Appeal Decision

Appeal Ref: 6004430

Land to the south of Bolton Fold Farm, Alston Lane, Longridge, Preston PR3 3BN

- The appeal is made under section 78 of the Town and Country Planning Act 1990 (as amended) against a refusal to grant planning permission.
 - The appeal is made by Mr Forshaw of N&K Forshaw Rental Properties against the decision of Ribble Valley Borough Council.
 - The application Ref is 3/2025/0141.
 - The development proposed is erection of 3no. commercial buildings (10 commercial units Use Class B2, B8 and sui generis) and associated works.
-

**Drawing Title**  
 PROPOSED SITE PLAN

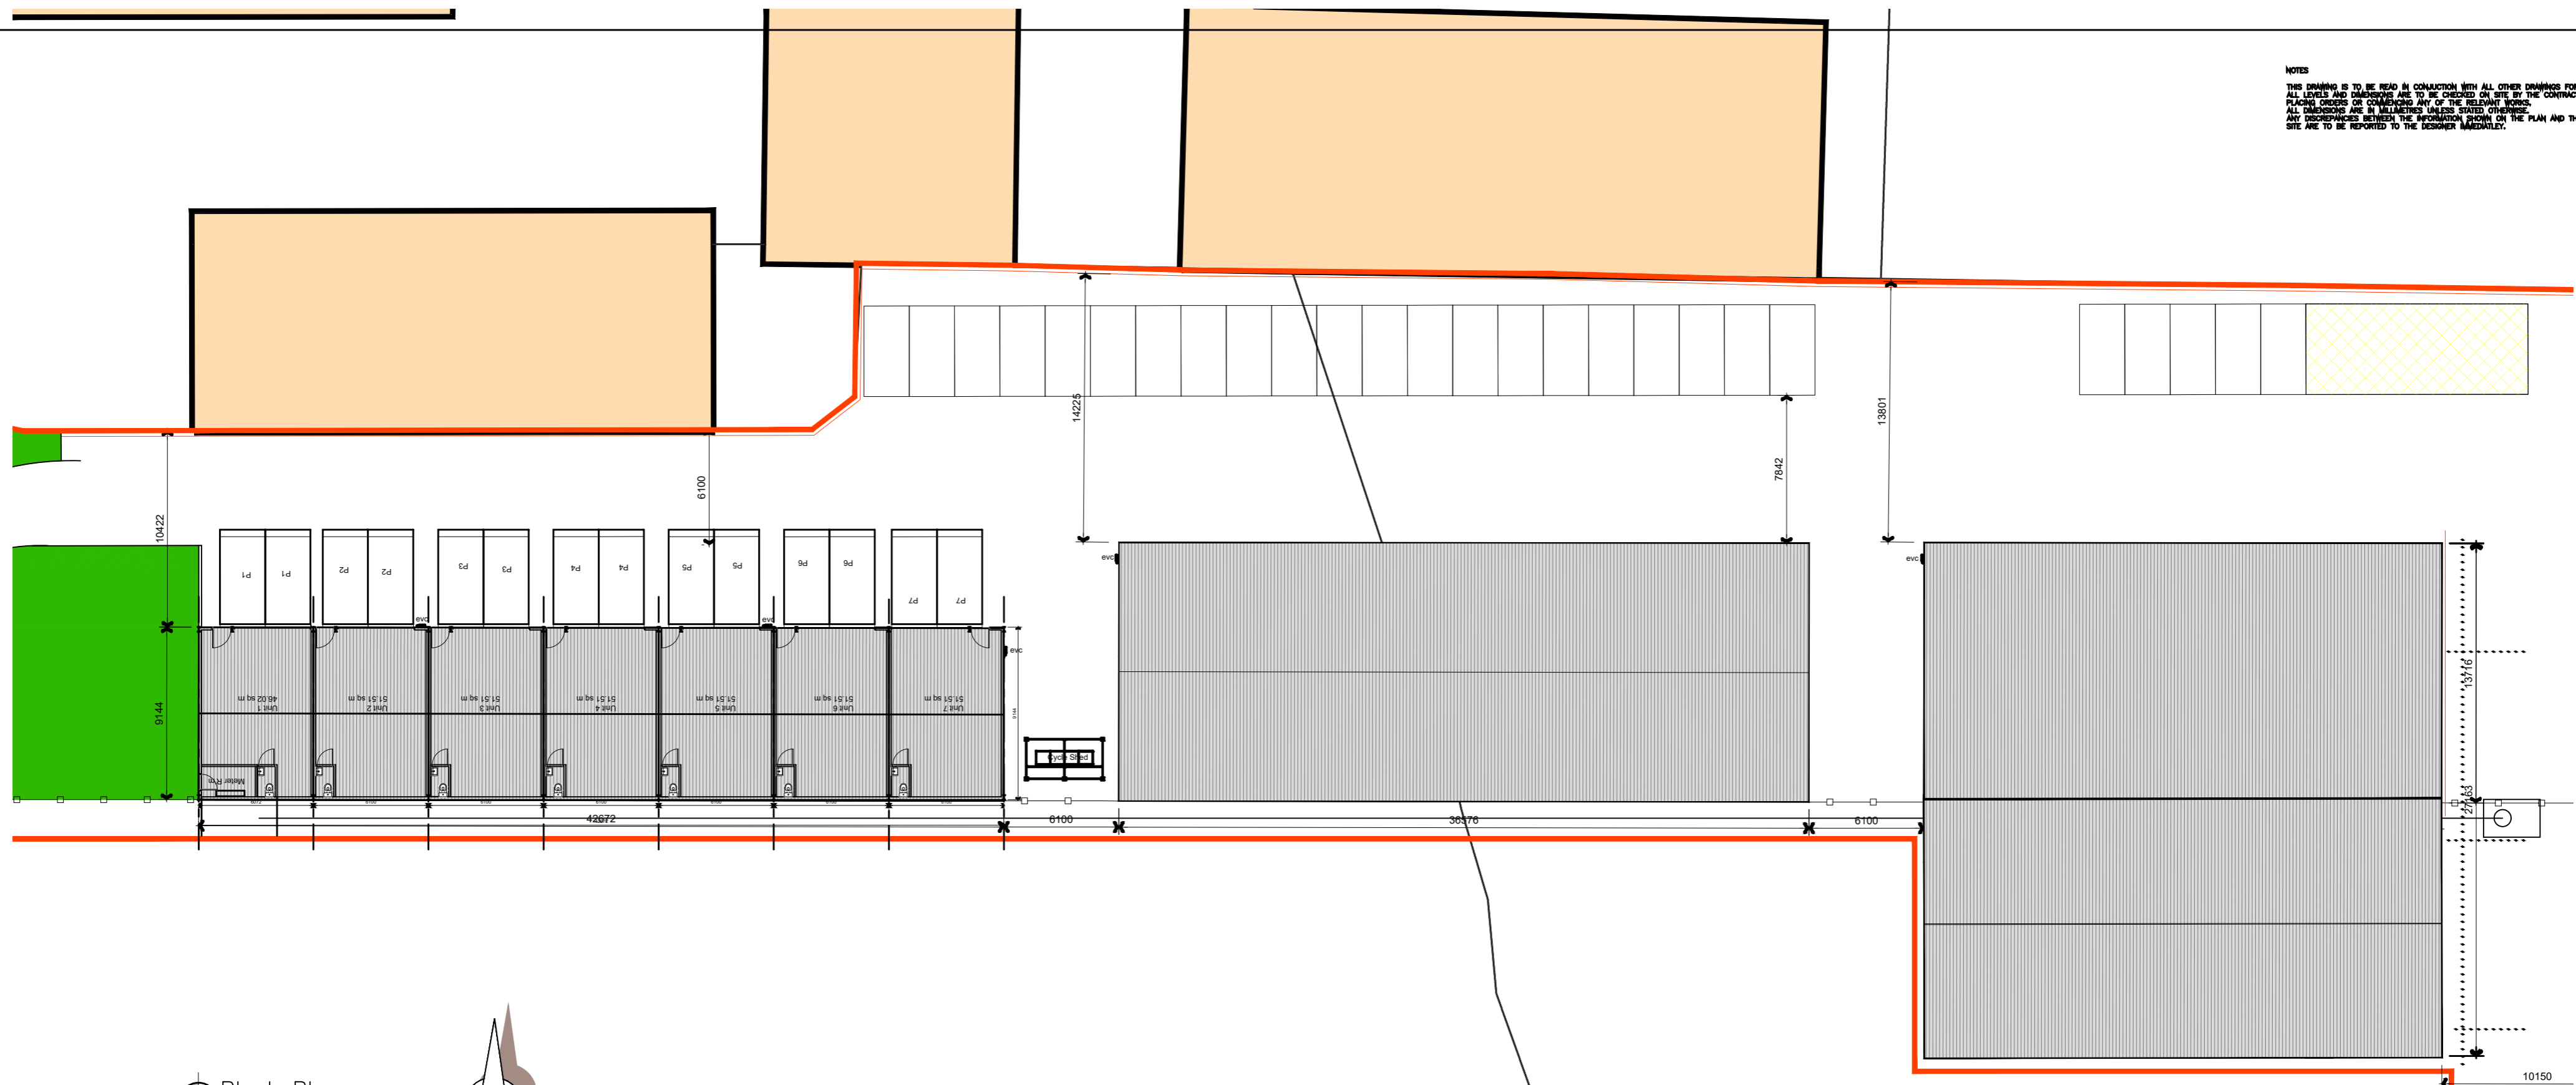
29. In time, the row of trees planted along one side of the internal access track will temper the appearance of the building closest to Alston Lane. Further, when viewed from Alston Lane, the existing hedgerow provides some screening of the long rear elevations, and the appellant has indicated a willingness to plant additional native hedgerows and field-edge trees. However, this landscaping cannot be relied upon in winter months, nor can be relied upon in perpetuity to hide development that would otherwise be harmful.

PROPOSED ELEVATIONS
 (UNIT 1)

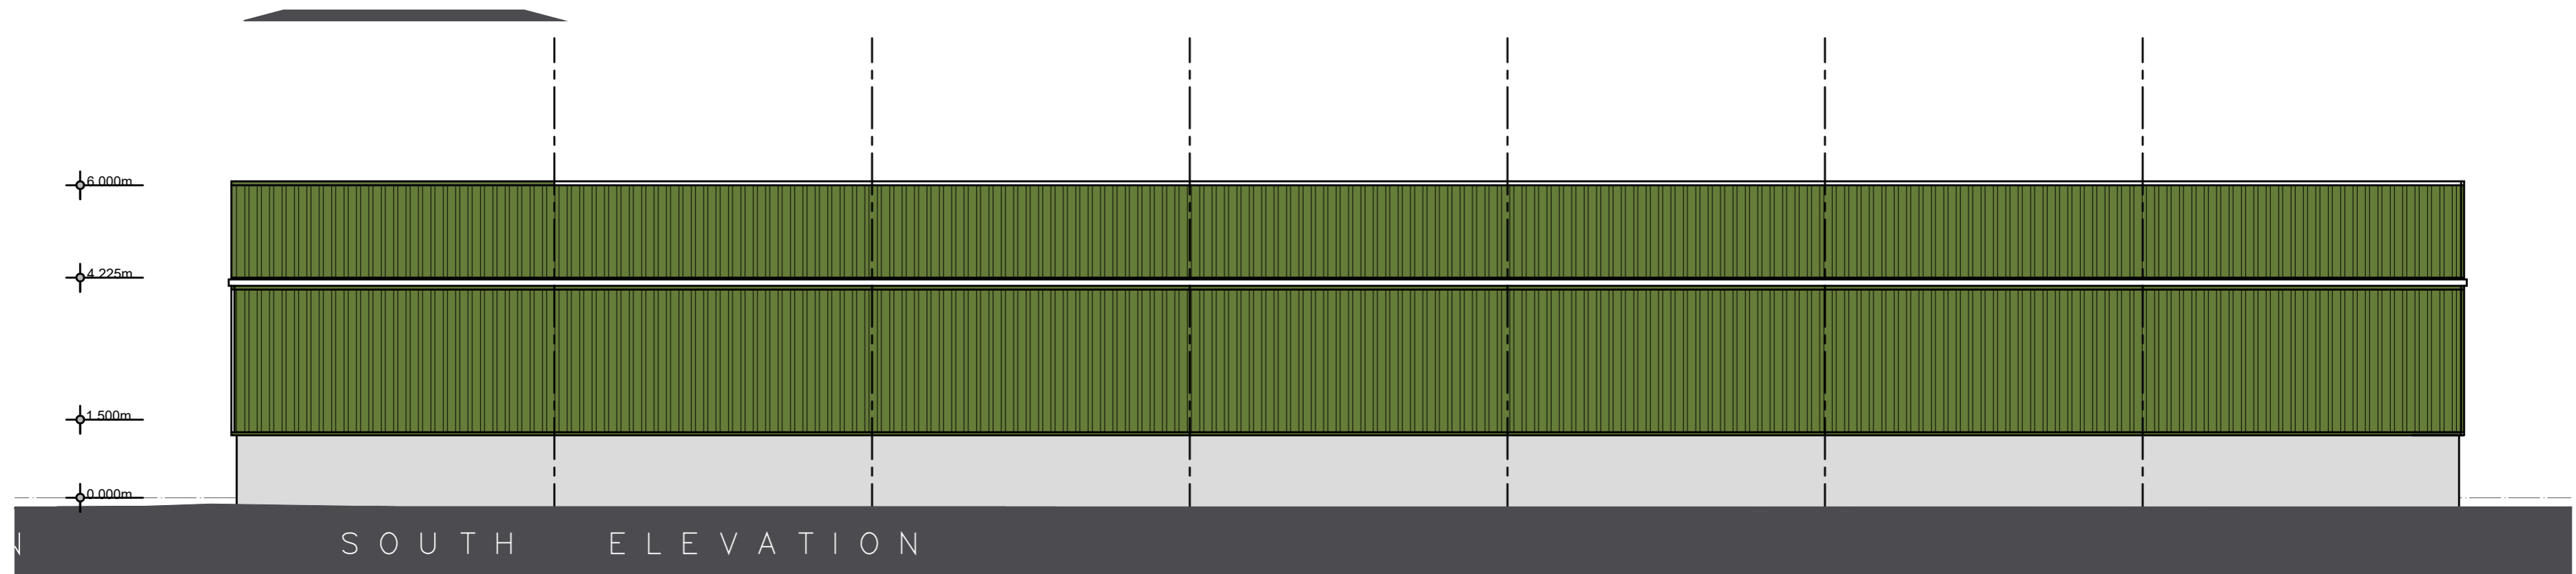
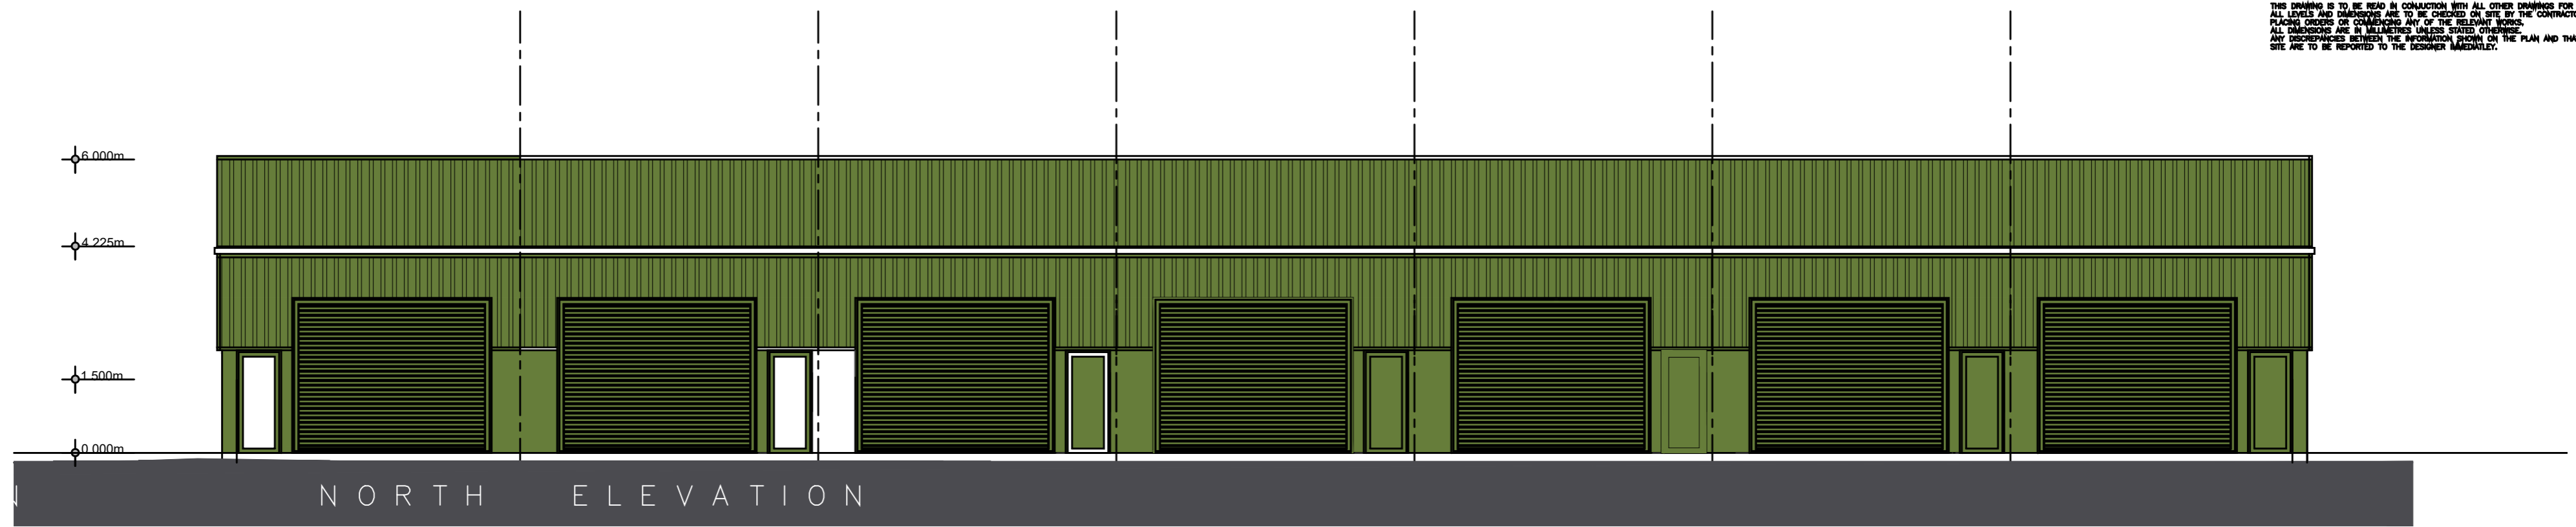
28. The development consists of three commercial buildings which are split into a total of ten separate units. Although substantial in size, their scale and simple dual pitched roof design is not dissimilar to the existing buildings to the immediate north. Orientated to face the internal parking area and a tall boundary wall, public views of the front elevations and the large roller-shutter doors are limited. However, whilst the appellant asserts it reflects contemporary agricultural building materials, I observed the green metal profiled cladding of the buildings, and the relatively wide concrete plinth, to be starkly industrial in character and appearance. Consequently, the buildings appear incongruous alongside the muted, more organic materials of the Bolton Fold Farm buildings which are mainly timber clad.

30. The Council's pre-application advice of February 2023 was that the retention of the units would not have an undue impact on the visual amenities of the area. Nevertheless, based on my own observations and judgement, the unsympathetic materials result in the buildings appearing unduly industrial, and they are a visually prominent and discordant addition to the otherwise rural, agricultural landscape.

31. I therefore conclude that the development causes harm to the character and appearance of the surrounding area. It conflicts with CS policies DMG1 and DMG2 and NP Policy LNDP3 which require all development to be of a high standard of building design which responds positively to local character and distinctiveness, is in keeping with the character of the landscape and sympathetic to existing land uses including building materials.
